Your Ref: OWPC22375
Our Ref: M/27/19/NMA 27-03-2019
Please ask for:
Mrs A Gardner

Non-material amendment following the grant of planning permission reference M/84/18/PL for changes to cladding and brick piers. Raising of roof level following Environment Agency advice.

Ohana 24 Alleyne Way Elmer Middleton-On-Sea

PROJECT TITLE		DRAWING TITLE		No	REVISION	DATE
Proposed Development at 24 Alleyne Way, Bognor Regis		Proposed Elevations				
		STATUS	Non material amendment			
		SCALE	1:100 @ A3			
		DATE	26.03.2019			
		DRAWN BY	AP			
		DRAWING No	NM-248-09

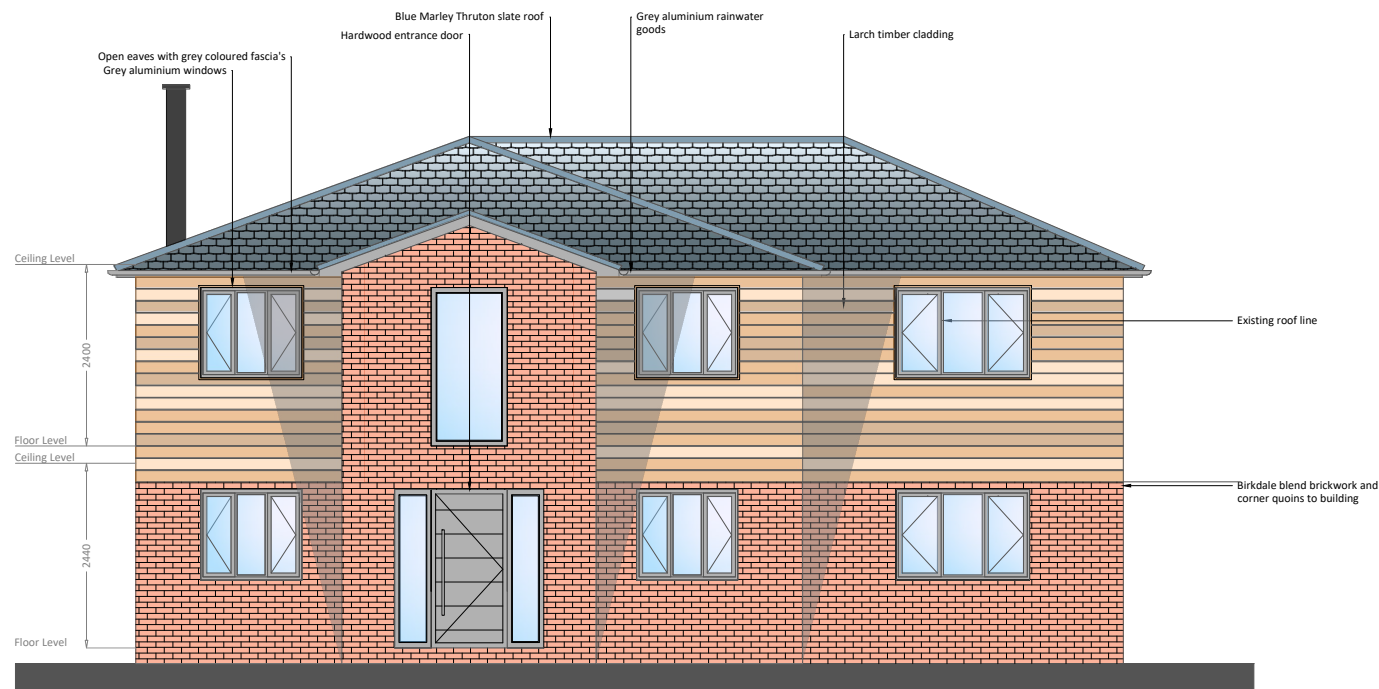
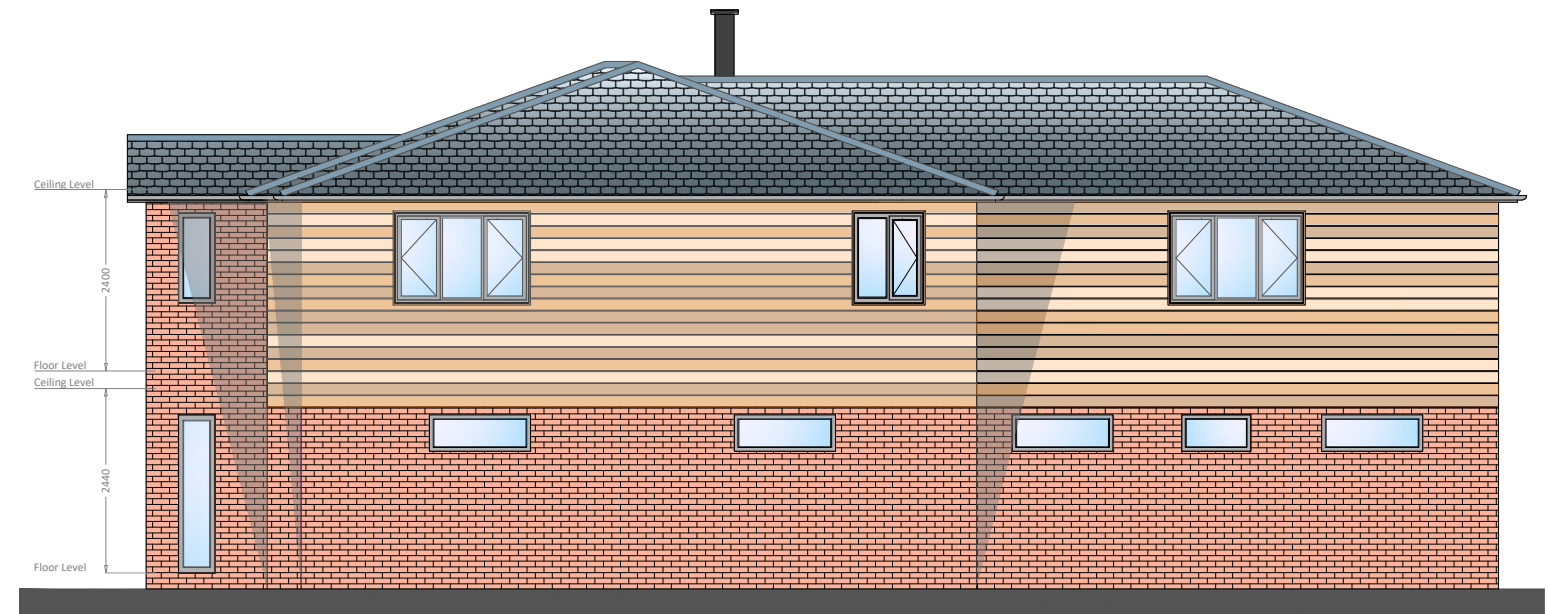
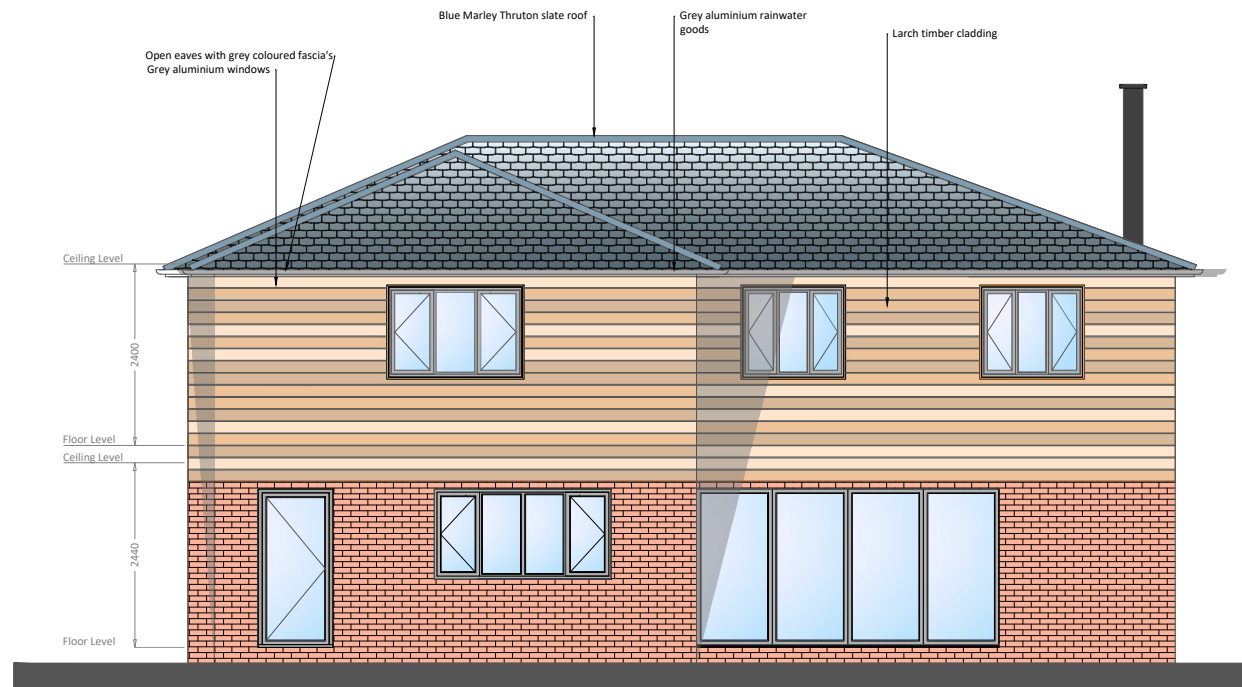
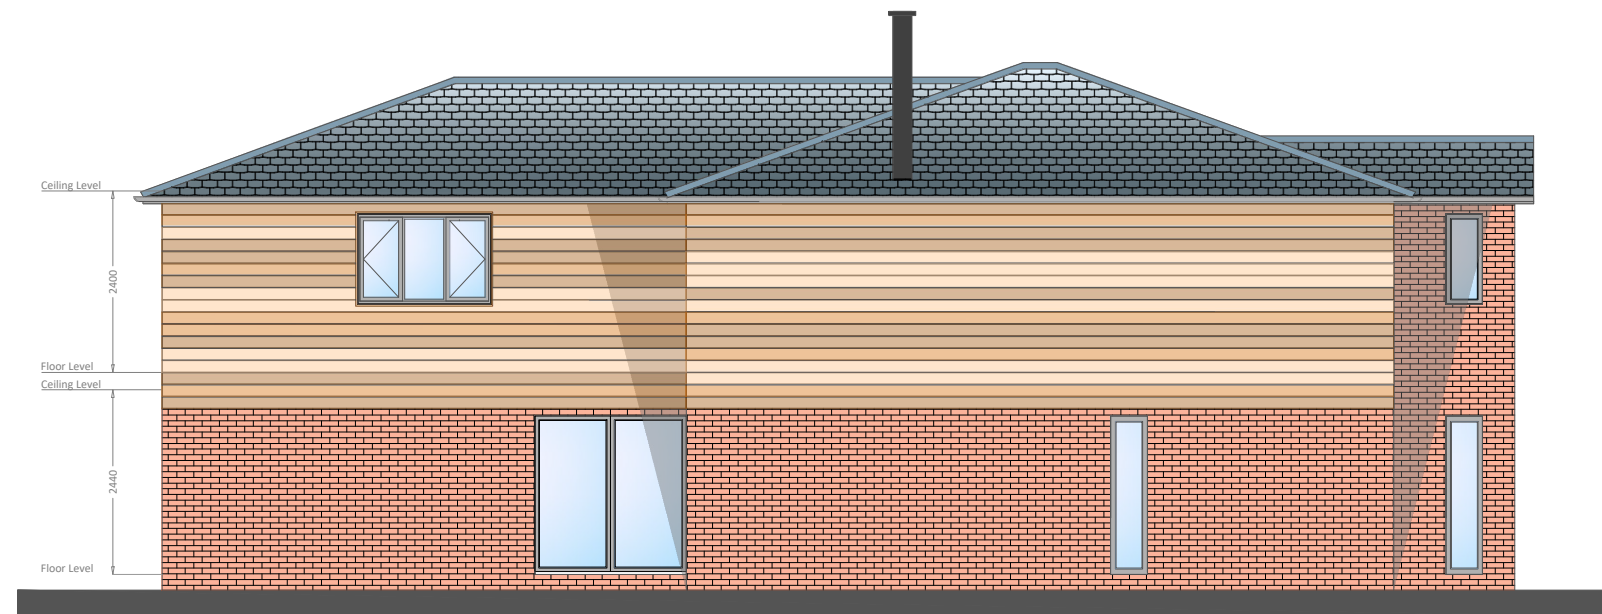
We now know that the development is to be 7.3m high due to the fact that the floor is to be raised by 300mm. Why do the plans not show this increased floor level? The south facing window to bedroom 2 is still shown to have 2 full opening panes, but is to be non-opening below 1.7m with obscure glass as a condition of planning approval.

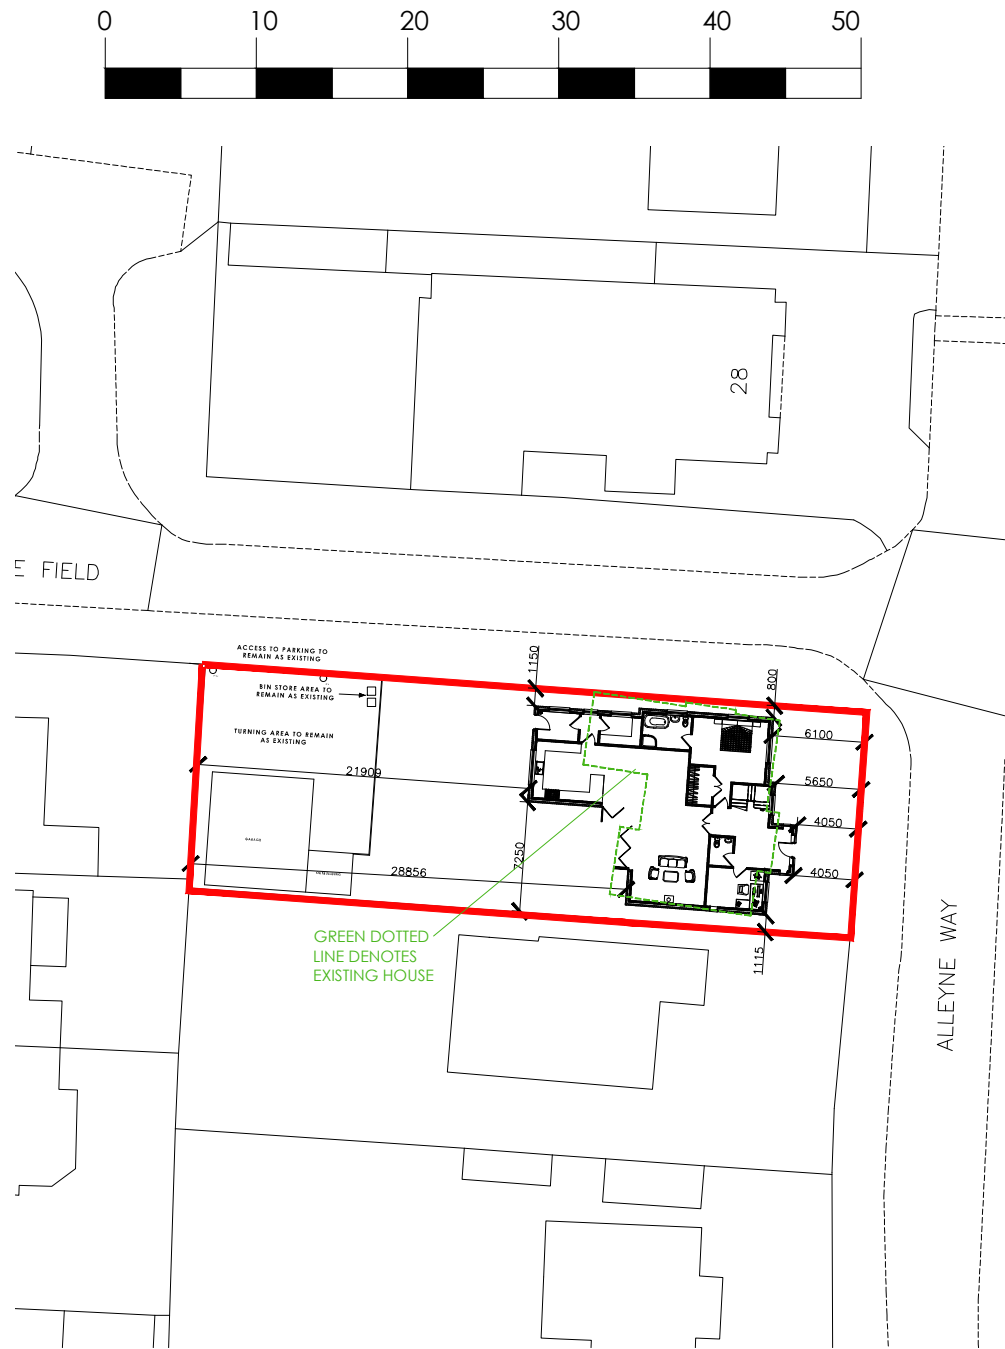
When the original application M/74/17/PL was submitted, we commented that the street view was inaccurate and definitely not to scale. This drawing is still presented but with 'NTS' as the scale. Would it now be beneficial for everyone, if a new street view was produced to show the correct scale of the development, and with a more accurate representation of the neighbouring house? Our house is 9.5m wide, whereas the new development is in excess of 12m. Our house is 1.4m from the fence line, whereas the new development is 1.115m.
